**Re: Minor Amendment to Site Plan
McDonald's 5301 Quail Rd. NW
Langan Project No.: 520055701**

Thank you for taking the time to review the Civil Plans for the McDonald's restaurant at 5301 Quail Road NW. We have addressed your comments as follows:

**\*\* NOTE TO CONTRACTOR - LOT RE-STRIPING \*\***

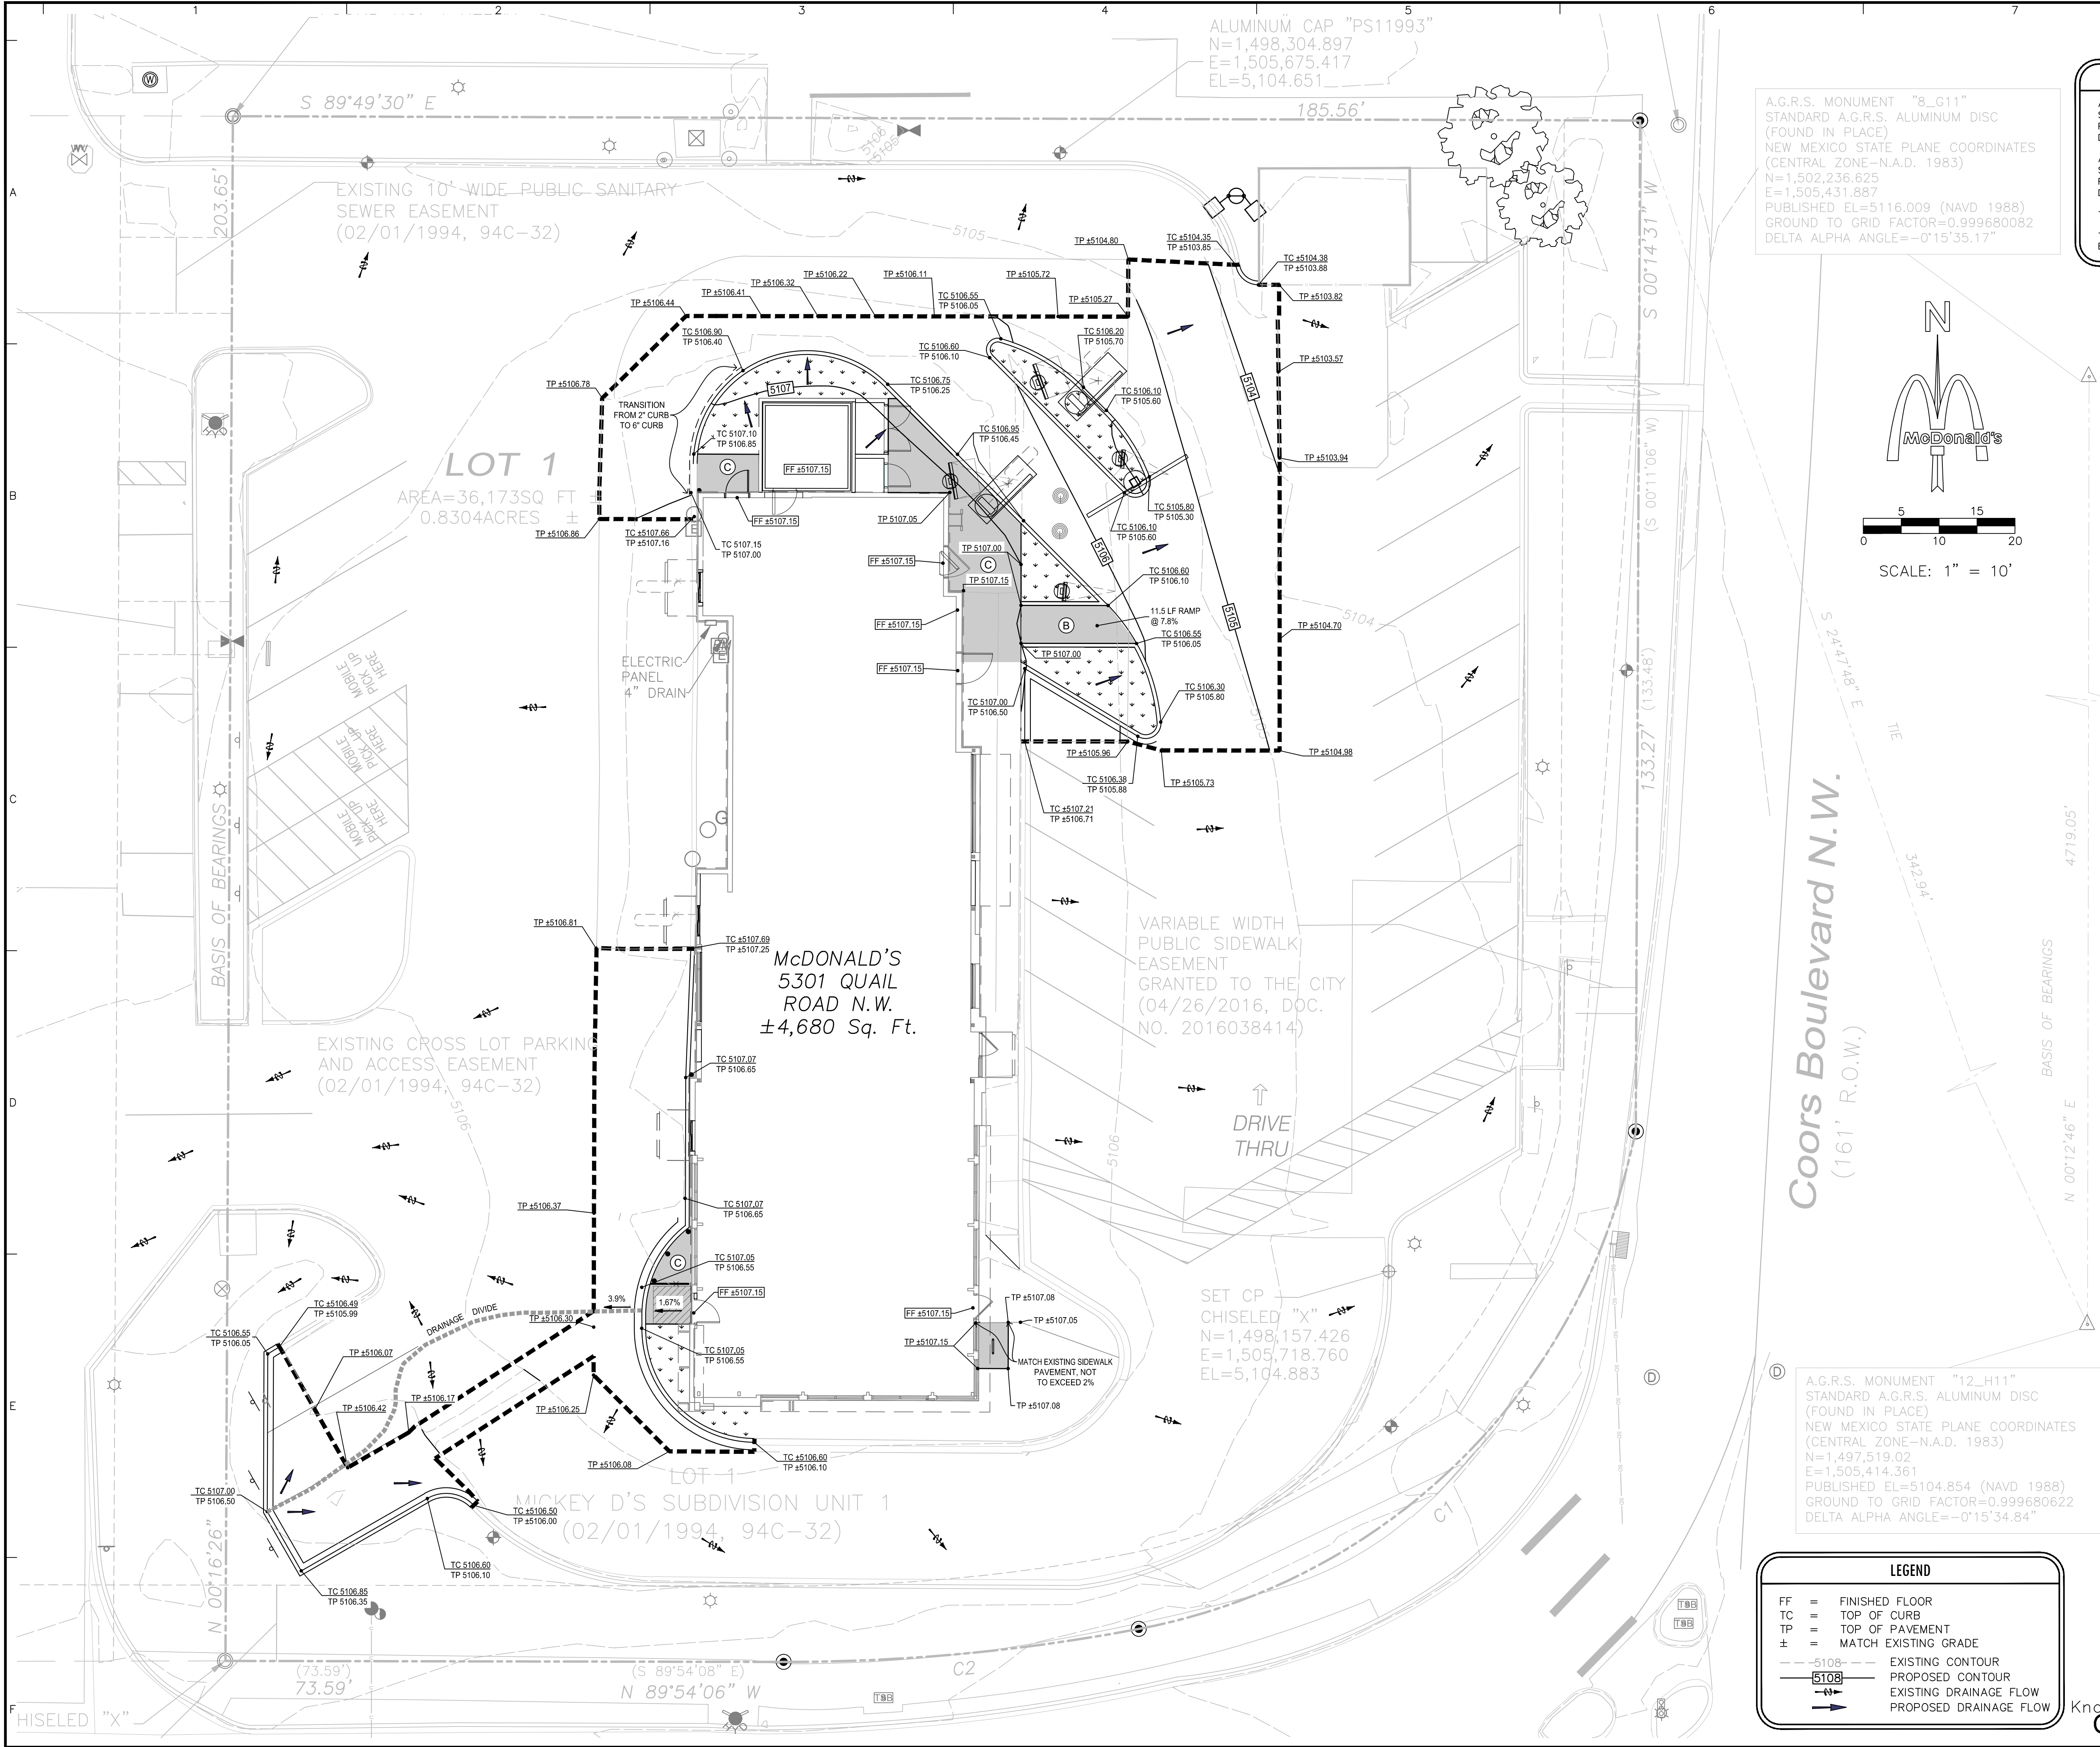
- 1) The location of the Handicap Parking is not shown on the Site & Paving Plan.
 - [The existing Handicap Parking striping has been added to the plan.](#)

- 2) The ADA accessible spaces must include an access aisle. Van accessible aisles should be 8ft wide; all others should be 5ft wide.
 - [The ADA accessible spaces include an access aisle. The van accessible space is 11' wide with a 5' aisle in accordance with ADA Standards 502.2.](#)

- 3) The ADA accessible parking sign must have the required language per 66-7-352.4C NMSA 1978 "Violators Are Subject to a Fine and/or Towing." Please call out detail and locations of signs.

- [Key note 7 has been modified to have the GC add the "Violators" signage to the existing Handicap signage.](#)
- 4) The ADA access aisles shall have the words "NO PARKING" in capital letters each of which shall be at least one foot high and at least two inches wide, placed at the rear of the parking space so as to be close to where an adjacent vehicle's rear tire would be placed. (66-1-4.1.B NMSA 1978)

- [The existing "NO PARKING" striping has been added to the plan.](#)
- 5) Please supply Detail Sheets (C6.1 – C6.5)
 - [The detail sheets are included in this resubmittal.](#)
